OBJECTION To : Planning Application AW/198/18/PL at Land between 8 – 12, Wychwood Close, CRAIGWEIL.

31st October 2018.

OBJECTION TO – AW/198/18/PL at Land Between 8-12 Wychwood Close, Craigweil,
Proposals for a New House within the Craigweil House Conservation Area.

DRAWING TITLE
Site Plan, Block Plan and Location Plan

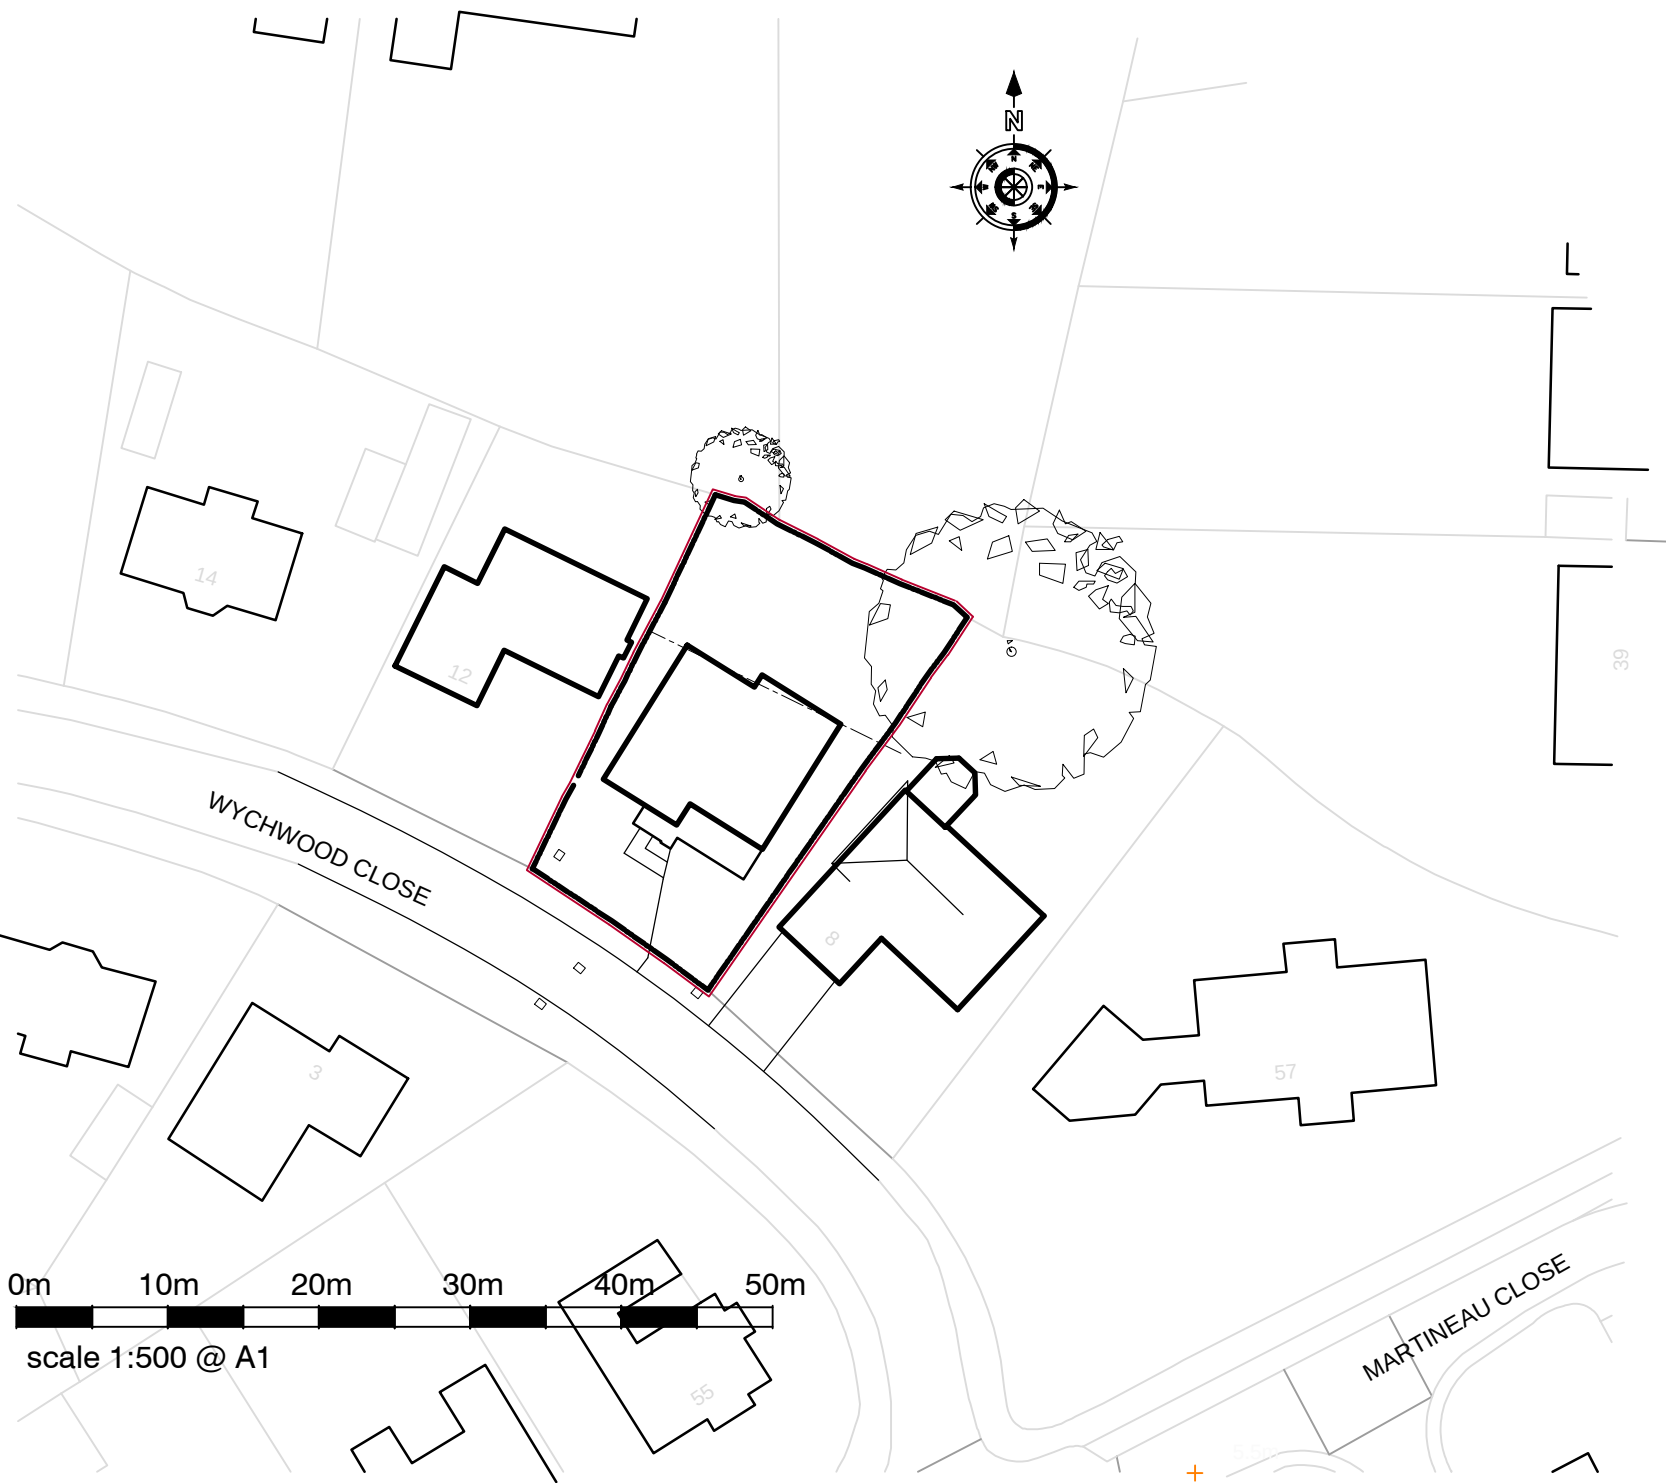
4. CHECAA submits that in this case, where permission is sought to create parking space to the front garden, the amount of surface area within the front garden proposed for hard standing is proportionally excessive, relative to the remaining space for green planting. Compared with the standards elsewhere in the CA, this degree of hard

standing exceeds the principle laid down in the Article 4 Direction and that with the expectation of 3 parked cars on the frontage, all will be exceedingly cramped, with the likelihood of spillage onto adjacent roadways. Entering the proposed space and equally exiting the space will create considerable problems both for the residents of the property and their neighbours both either side and opposite the site.

5. Further, there is no mention in this Application of the replacing of a tree, in the verge outside the curtilage of the property, removed by a previous owner of this plot of land, in CHECAA's opinion illegally. The tree was removed to make way for the current development with a 'promise' that it would be replaced. We think that at the very least there should be acknowledgement of this position and a repeated commitment to replace a tree. The planning Application number of the tree's removal etc. was AW/128/16/T. **I attach for reference a copy letter** from myself regarding that Application.
